PROJECT NO. 2020-004757

DESCRIPTION: Resubmittal to the Development Review Board after addressing comments from the  
initial review meeting on March 31, 2021.

**RE: RV Storage – Albuquerque: DRB Resubmission**

## **COMMENT RESPONSE LETTER**

**RV STORAGE - ALBUQUERQUE
 ALBUQUERQUE, NEW MEXICO
 SITE PLAN
 UTILITY PLAN**

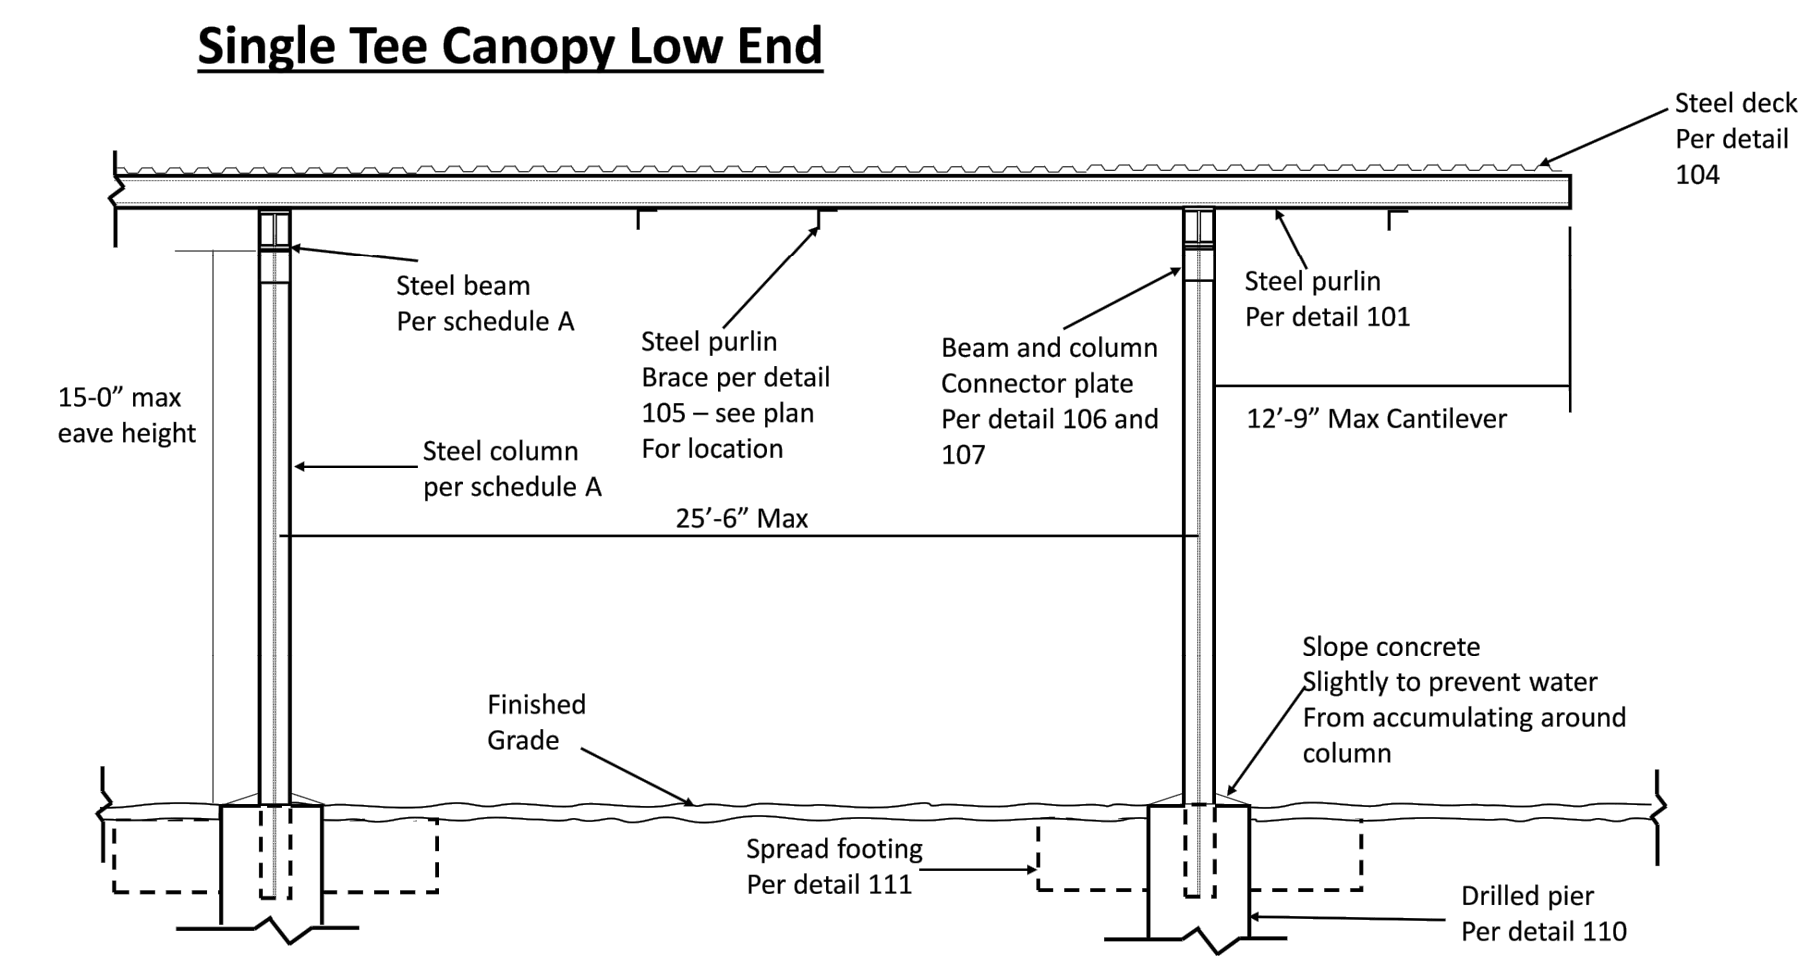
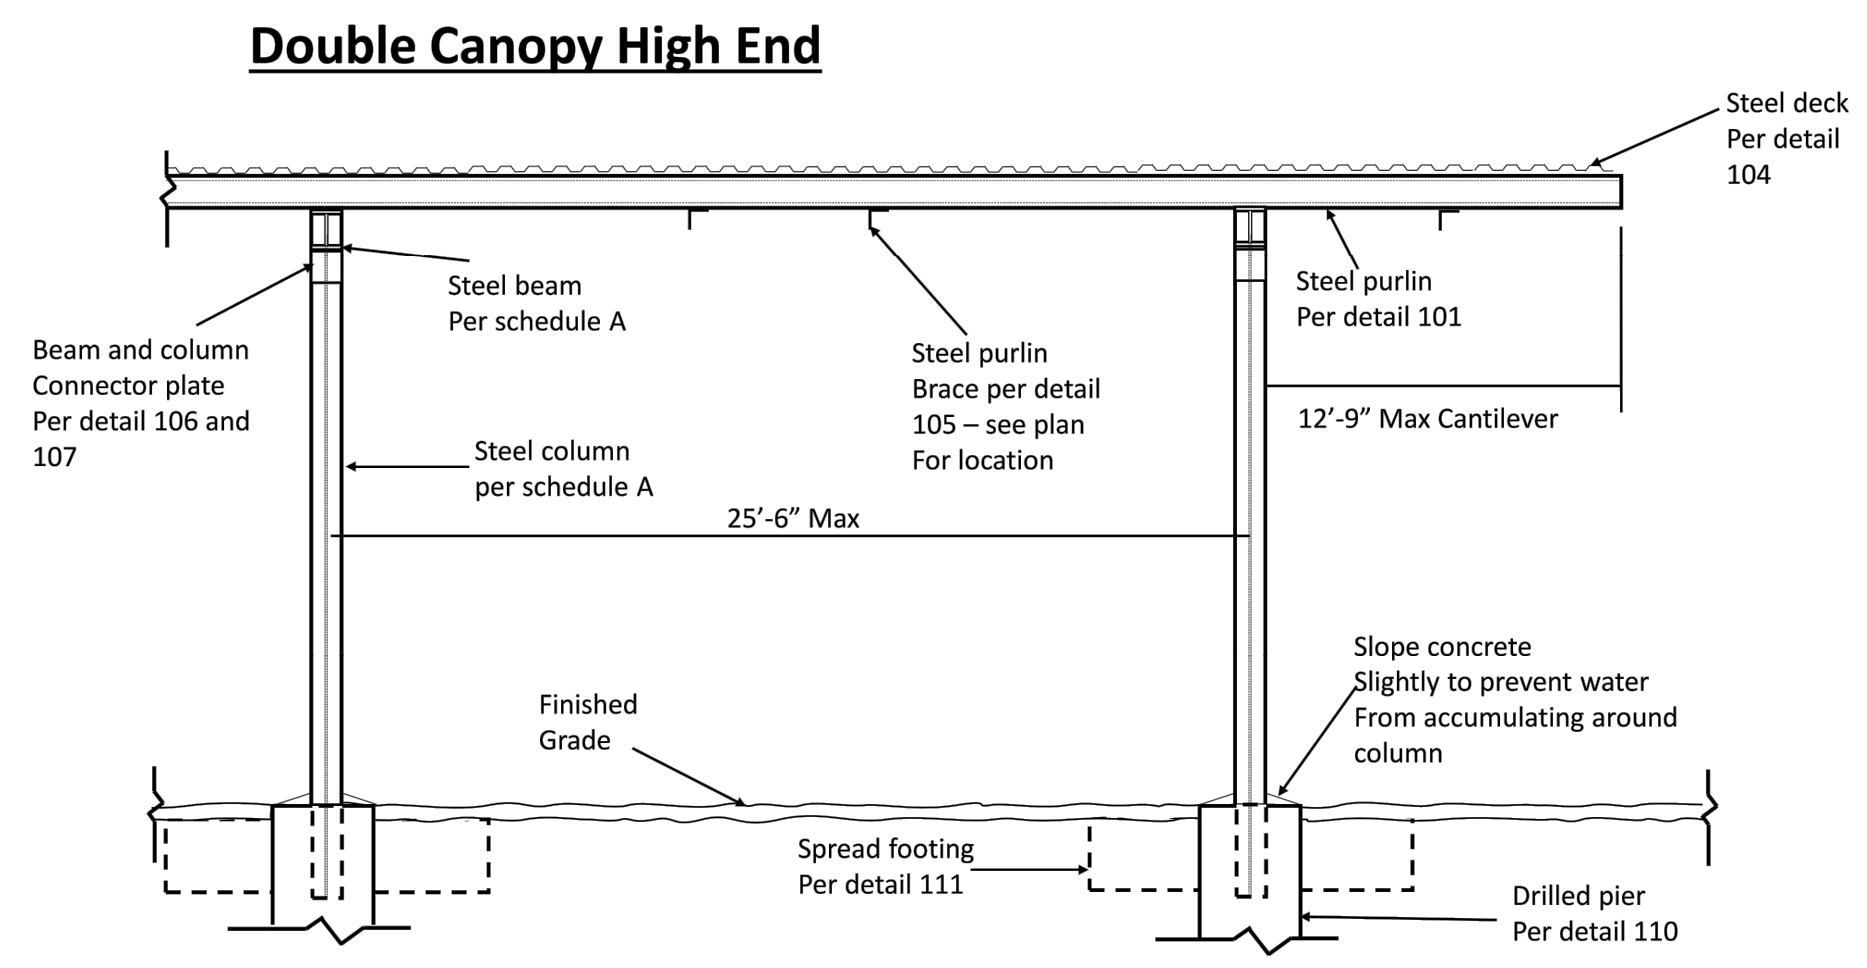
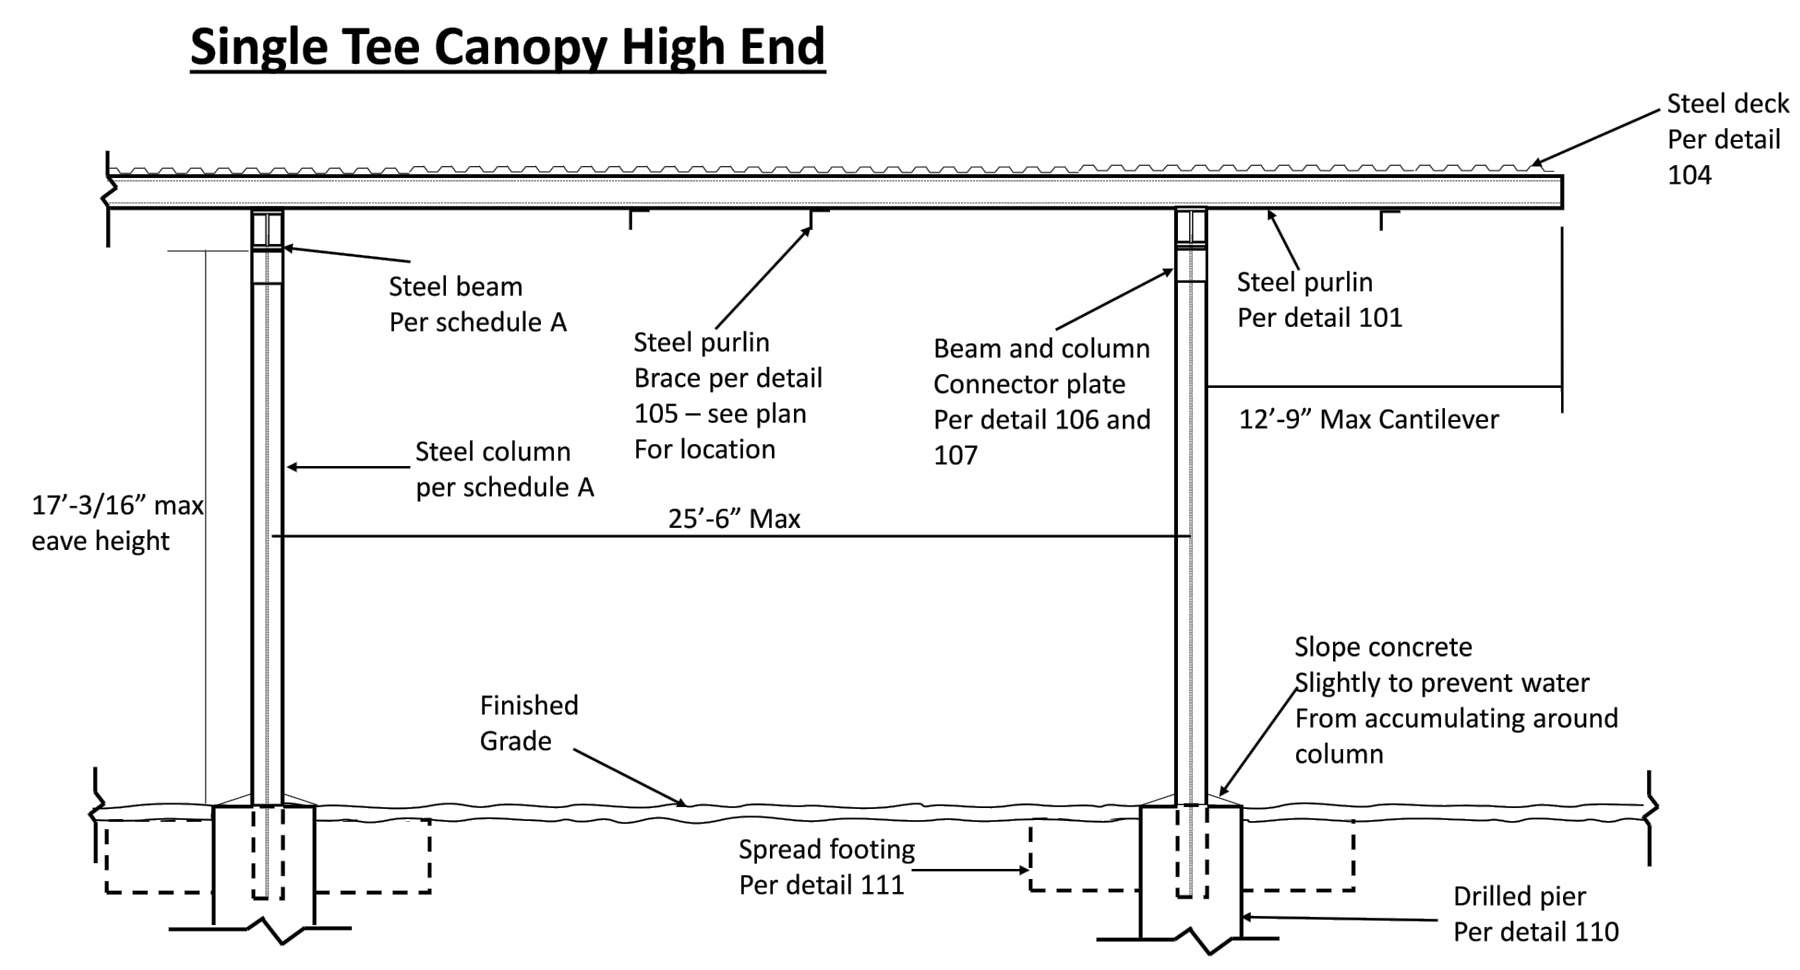
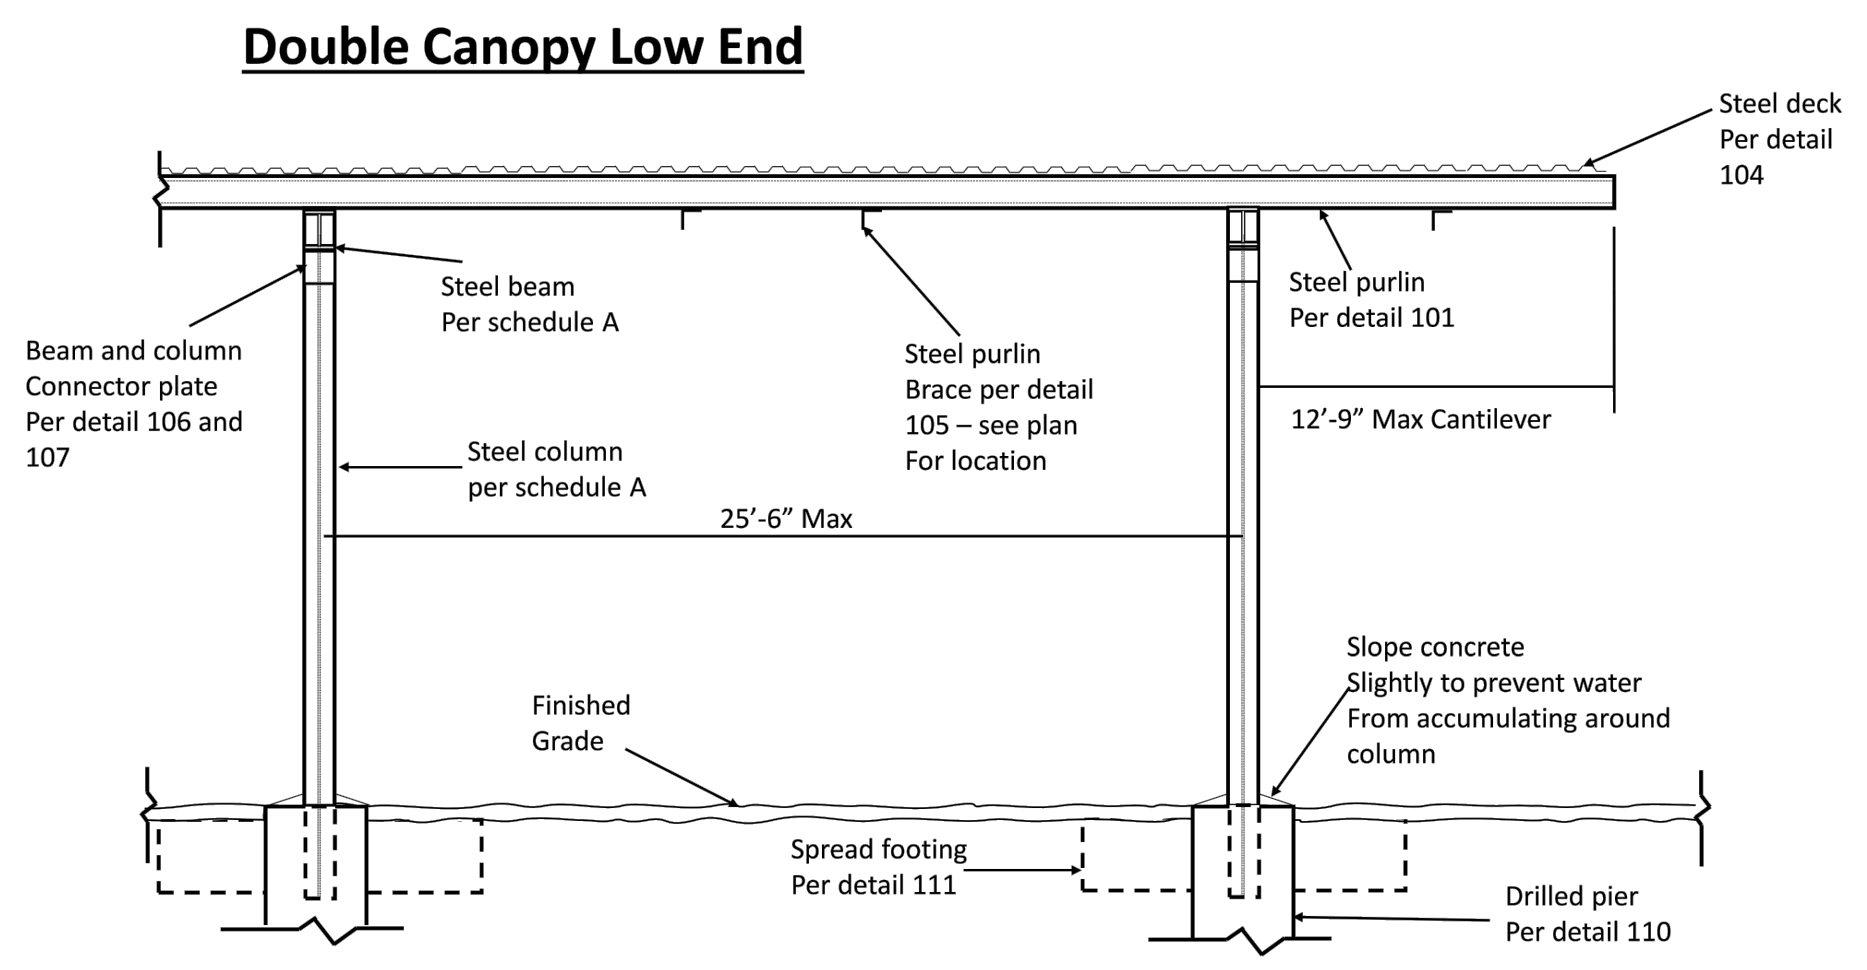
2. Public improvements to extend sanitary sewer mains will be required. A water main upsizing is also anticipated. Please update the utility plan as required upon receipt of the availability statement.

- *Response: Acknowledged. A water main upsizing has been accounted for, and the utility plan has been updated.*
3. The proposed 8" PVC sanitary sewer line will need to be revised to depict a typical perpendicular connection to a new public sanitary sewer main in Volcano Road along the project frontage.

- *Response: Acknowledged. An infrastructure list has been included.*
5. Please clarify the utility plan.
  - A. What size meter is proposed? What size line is following the meter?

- B. Is a private fire line required? If so, show the connection to the main. This is listed in the key note but not the plan view. Fire lines are unmetered and should be constructed per the ABCWUA standard detail. This includes both a public and private valve.

- C. Please clarify the purpose of providing an internal looped water line.
  - D. Please clarify the size of the proposed onsite sanitary sewer line. Is this supposed to be 8" PVC?

- *Response: Acknowledged. The sanitary sewer line has been extended to the property line.*
4. An infrastructure list will be required for the public water and public sewer improvements.

- *Response:*
      - *A. The proposed meter and line following the meter are both 1".*
      - *B. A private fire line is required. The connection to the main has been shown and the detail has been included.*

- *C. The internal looped water line has been removed.*

- *D. The proposed onsite sanitary sewer line is 6" (size may alter based upon the plumbing requirements for a wash station, during detailed design)..*
